Application Ref:	3/2021/0039	 Ribble Valley Borough Council www.ribblevalley.gov.uk	
Date Inspected:	1/4/2021 and 21/5/2021 and 16/11/21		
Officer:	AD/JM		
DELEGATED ITEM FILE REPORT:		Decision	Approval

Development Description:	Replacement timber windows, proposed internal works and refurbishments.
Site Address/Location:	Back o'Thorn 25 Brookside Downham BB7 4BP

PROPOSED INTERNAL TIMBER CLADDING DETAIL SCALE 1:10

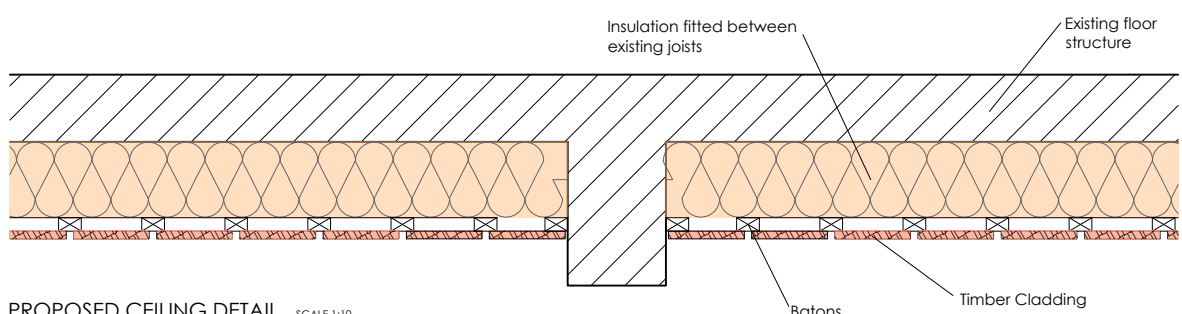
Wall lining/cladding

Internal plaster to be removed is a combination of cementitious and traditional lime plasterwork. The impact of dry-lining (with insulation) walls on building 'breathability' has not been made clear. The appearance of walls will be changed – undulations, imperfections and variety to surfaces produced by centuries of ware will be replaced by overtly modern, regular and uninteresting surfaces (see 'Making changes' paragraph 50; IHBC 'Alterations to Listed Buildings' 2021 paragraph 3.12.2). Historic room proportions and shape will be affected by cladding to some walls and not others.

PROPOSED GROUND FLOOR DETAIL SCALE 1:50

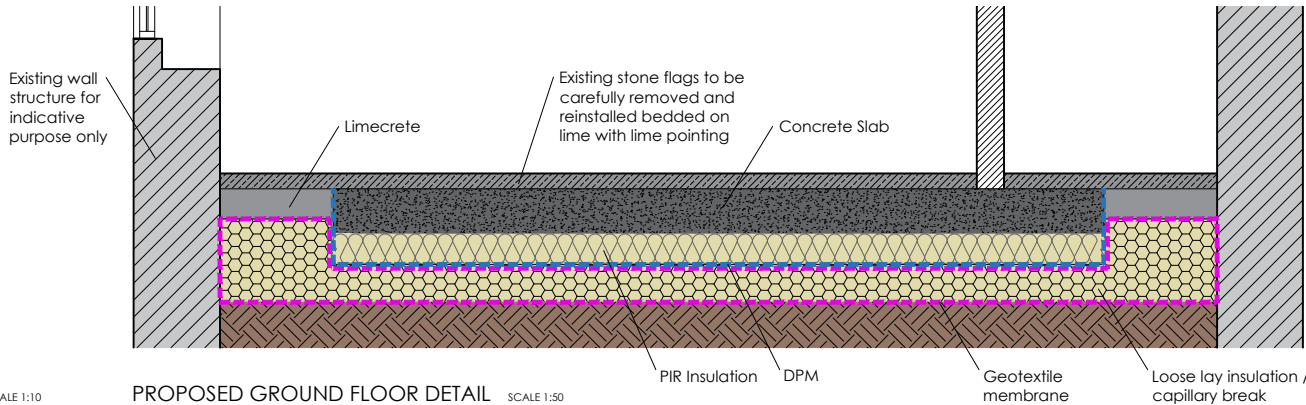
New ground flooring

The recent SPAB advice 'Caring for Old Floors' (and Historic England 'Making changes to heritage assets' paragraph 47 and 51) has been considered. The historic flag flooring is worn, uneven and has a 'patina of age' reflecting centuries of use which is authentic and intrinsic to the listed building's character. This authenticity and character will be lost by excavation and re-forming. The submitted Heritage Statement identifies "The archaeological interest of the building is derived from its plan form layout and extant historic fabric which provides tangible evidence of its past domestic use". In respect to historic interest, "the retention of internal historic features such as fireplaces, slop stone and the possible brick oven / stove is not entirely commonplace as such features are usually removed or significantly altered, as is the case to the adjoining No.25". In general, "the significance of the building is derived from, its extant historic fabric, its evidence of past historic alteration and its remaining internal domestic features which have only been retained in no.24".

Furthermore, the potential impact of damp proof membrane inclusion on building 'breathability' has not been explained.
